Our Ref: BN/160/21/NMA

Non material amendment following the grant of BN/39/20/PL for Plot 1 (internal amendments not impacting externally), chimney handed to other side of dwelling & stepped access introduce; Plot 4 (internal amendments not impacting externally) & bulk of dwelling handed with chimney moved to external wall.

Tars Farm Land at Church Lane Barnham PO22 0DB

| 0412-NMA-A110 | -         |

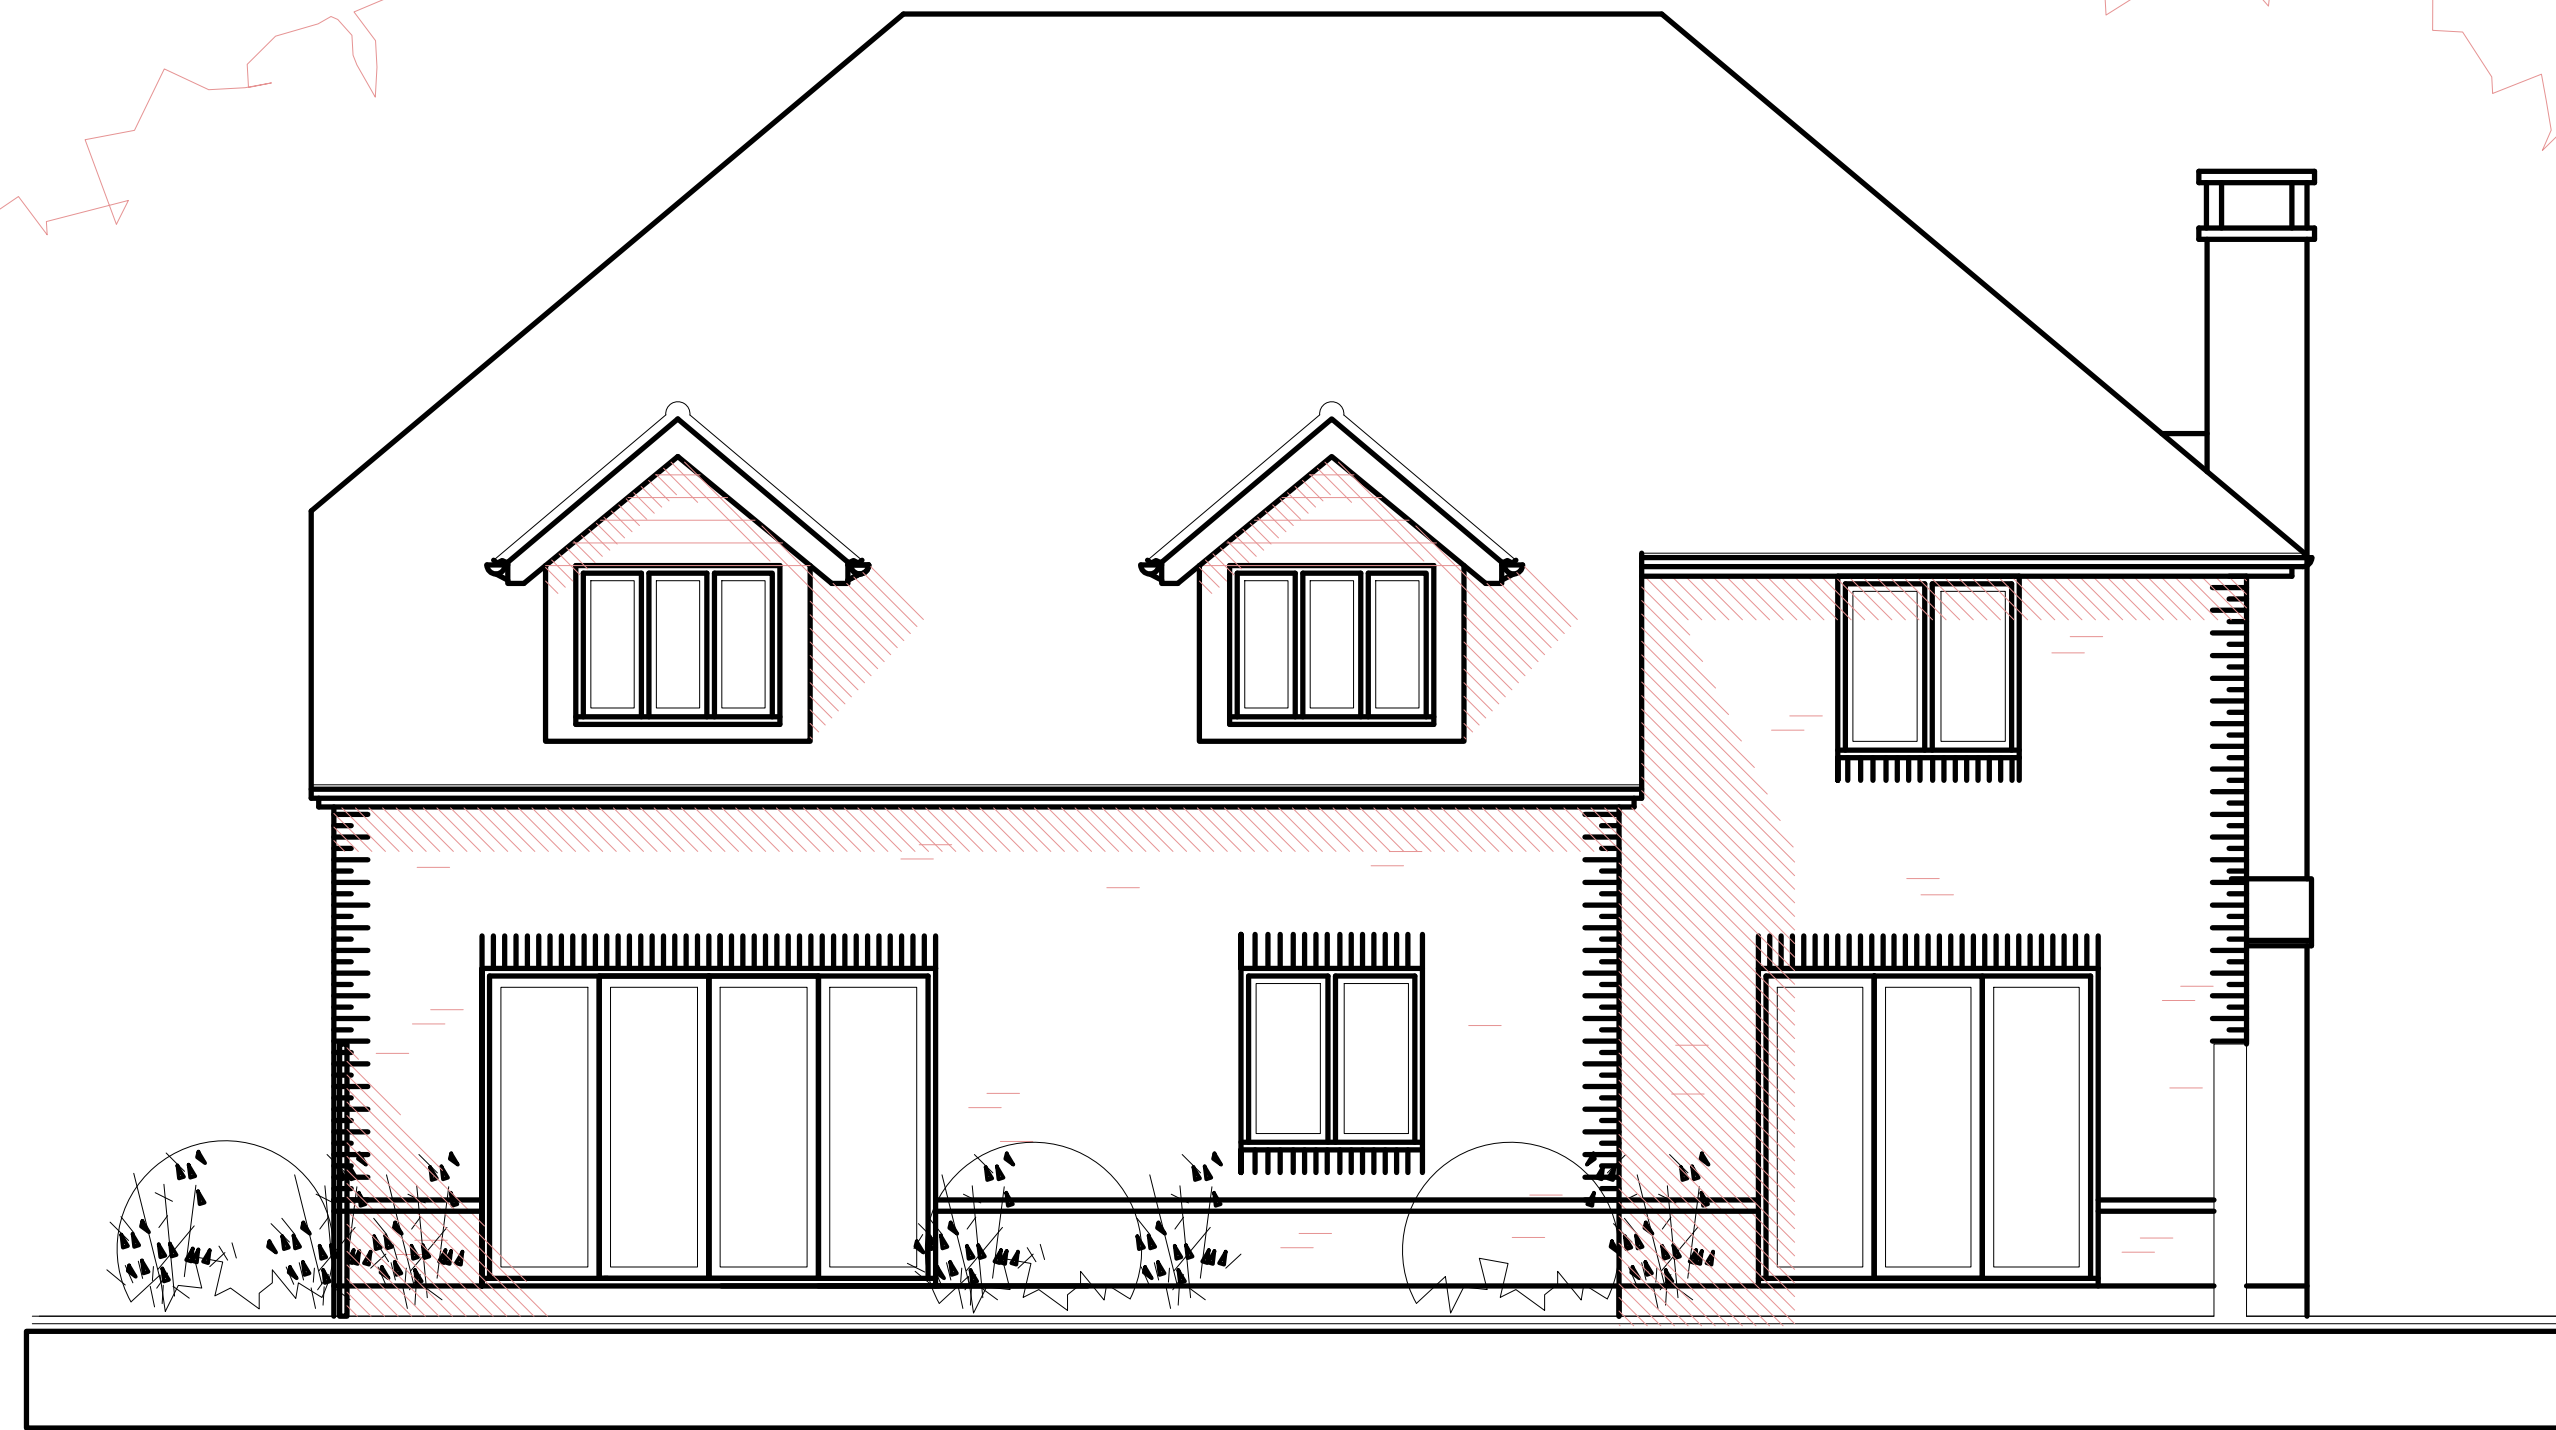
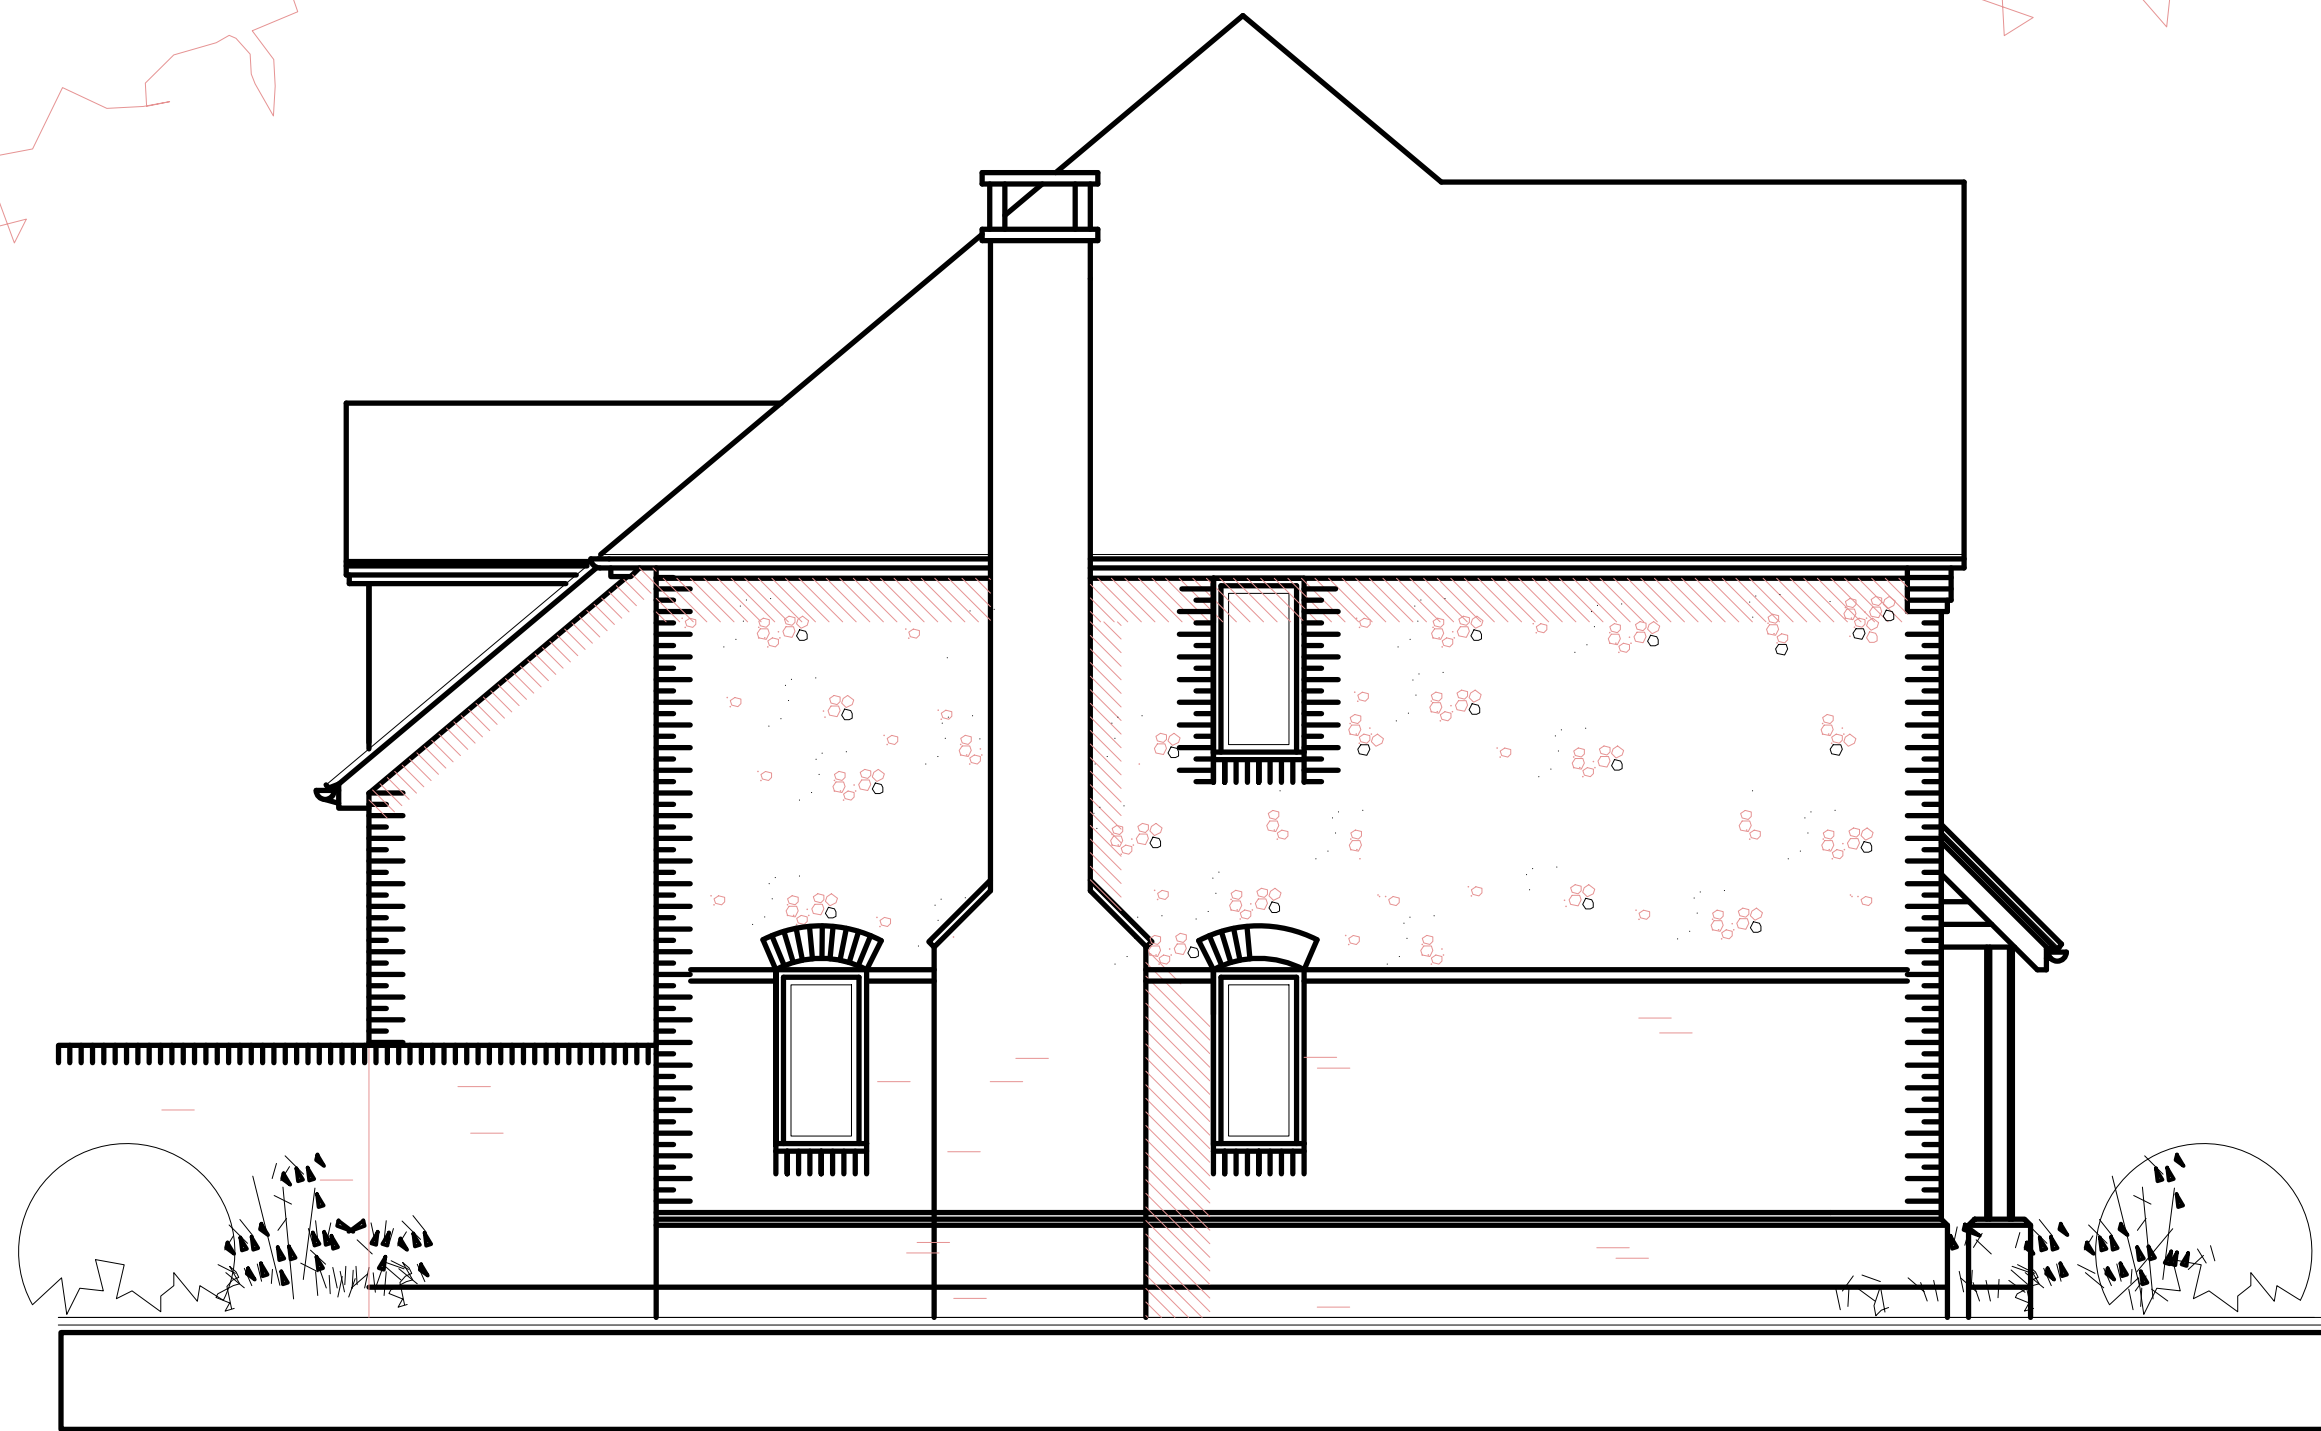
- Plot 1: internal amendments, chimney handed from the north to the south flank elevation, introduction of stepped access to the front door & north facing ground floor door removed; and
- Plot 4: internal amendments, ground floor window on rear of attached garage moved and door introduced, chimney stack introduced on the west side (relocated from the south facing rear roof slope), ground floor west flank window positions handed and a window to replace a door on the east elevation (ground floor).

These changes will not materially alter the appearance of the development approved by the planning permission, do not conflict with any conditions of the permission, do not breach any planning policy and do not warrant re-consultation. Whilst a new chimney stack on the west elevation of plot 4 is introduced, this is lower than the height of the approved chimney and does not extend further out from the flank wall than the approved bay window on this elevation (and in any case adds less than 1m extra width). All fenestration changes are at ground floor and due to boundary treatments, do not affect neighbouring properties.
